The Drovers Solar Farm

Statement of Common Ground (SoCG) with Environment Agency (Clean)

Document reference: APP/5.13.2 (Revision 2)

DRAWING TITLE:
Figure 12.15: Work No. 4 Maximum Potential Foundations and Groundwater Elevations

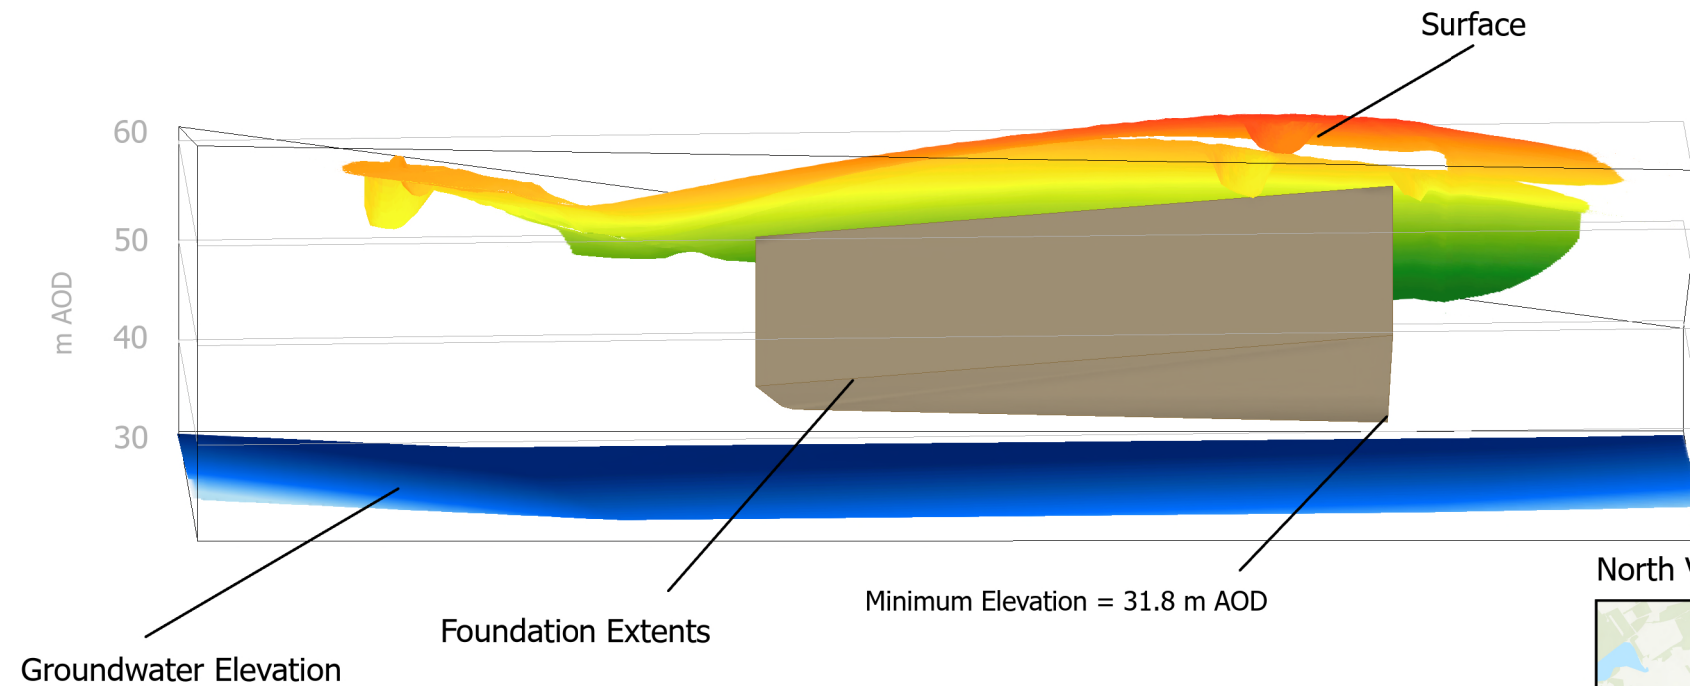
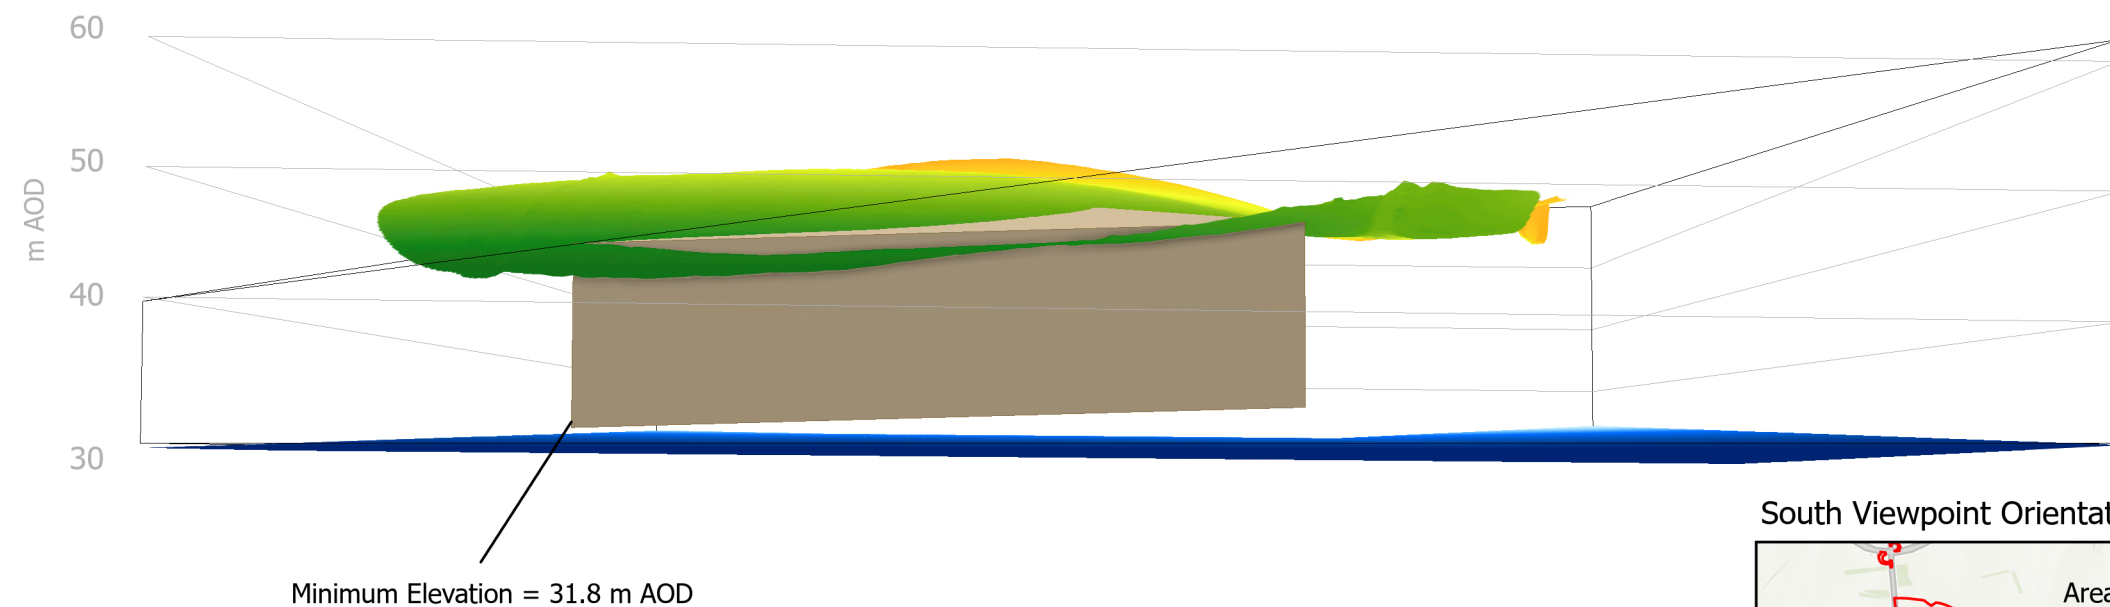
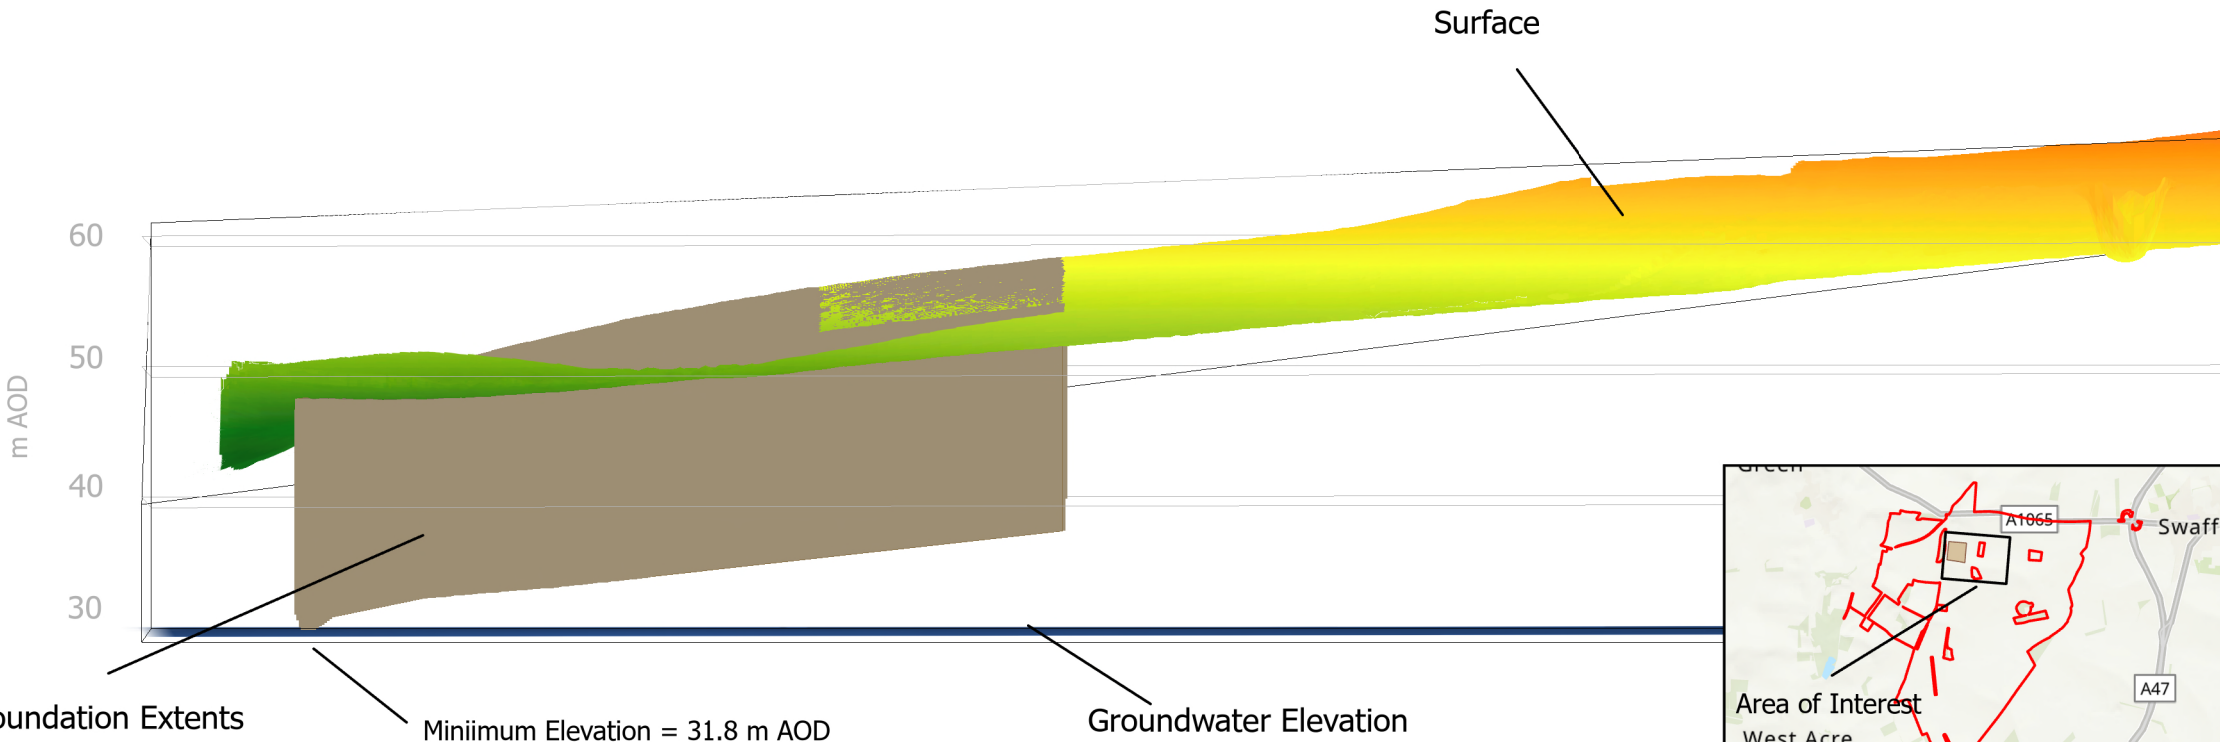
Reference	EA Issue Reference	Topic	Consultee's Position	Applicant's Position	Status
2-1	EA05	Maximum Foundation Extents	We are satisfied and consider this issue resolved. We were concerned that figures 12.13 [APP-127], 12.14 [APP-128], 12.15 [APP-129] and 12.16 [APP-130] do not clearly define the area represented by the drawings, including view orientation, or the elevation values. We have reviewed the following:	Figures 12.13 to 12.16 of ES Chapter 12: Water Resources [APP/6.2.3] were used to illustrate the maximum groundwater elevation surface across the Core Study Area and identify where proposed foundation depths could theoretically intercept shallow groundwater under worst-case conditions. The figures also demonstrate at a concept level where piling may be required depending on foundation design.	Agreed

• 6.3.1 ES Figure 12.13 Work No. 2 Maximum Potential Foundations and Groundwater Elevation [REP3-043] • 6.3.1 ES Figure 12.14 Work No. 3 Maximum Potential Foundations and Groundwater Elevation [REP3-044] • 6.3.1 ES Figure 12.15 Work No. 4 Maximum Potential Foundations and Groundwater Elevation [REP3-045] We find the updated figures satisfactory for defining the 3D model view, and elevation the maximum extent of the foundations	The following changes were made at Deadline 3 to aid the EA's interpretation: • Addition of orientation labels or description • Elevation shading to show mAOD values for the maximum groundwater elevation surface and foundation extent surface • Highlight areas where foundations intersect or exceed groundwater elevation surfaces; and • Figures and text refer to groundwater elevation (mAOD) rather than groundwater level to increase clarity between absolute elevation and depth below ground. The Applicant agrees that the conceptual model present is not the final tool for foundation design, but rather to provide a screening-level assessment of groundwater conditions and to identify areas needing piled or shallow foundations and will be aligned with EA regional groundwater understanding (NEAC model). The Design Principles, Parameters Commitments [APP/5.8.4] was updated at Deadline 2 to commit to foundations not directly interacting with groundwater. The Applicant maintains the position that a potential interaction of up to 1 m has been

determined for a very small section of Work No. 4 and that Figure A12-1-10 displays this minimal interaction northeast of Work No. 4, should the full Work No. be developed.	
2-2	EA38	Storage of Waste Batteries	We are satisfied and consider this issue resolved. We were concerned that there was an absence of mitigation measures relating to the storage of waste batteries. The 7.14.1 outline Battery Safety Management Plan (Tracked) [REP3-072] has been updated to include suitable measures.	An outline Battery Safety Management Plan (oBSMP) [APP/7.14.2] has been prepared as part of the DCO Application which sets out the mitigation measures to be secured via Requirement 6 of the draft DCO [APP/3.1.4]. The oBSMP [APP/7.14.2] has been updated at Deadline 4 to confirm the management of damaged or end-of-life batteries by the following: End-of-life or damaged BESS units are to be electrically disconnected from the system when identified as being required. When disconnecting damaged or defective units, a specific risk assessment shall be conducted prior to the removal of the defective module to ensure the safety of employees and contractors. Damaged or defective units will be inspected and placed in an approved protective container prior to being transported from Site, to ensure against any risk of contaminants entering ground- or surface water. End-of-life batteries awaiting regular replacement will be stored in situ. This is considered most appropriate due to existing contamination bunding and surface-water runoff protections associated	Agreed
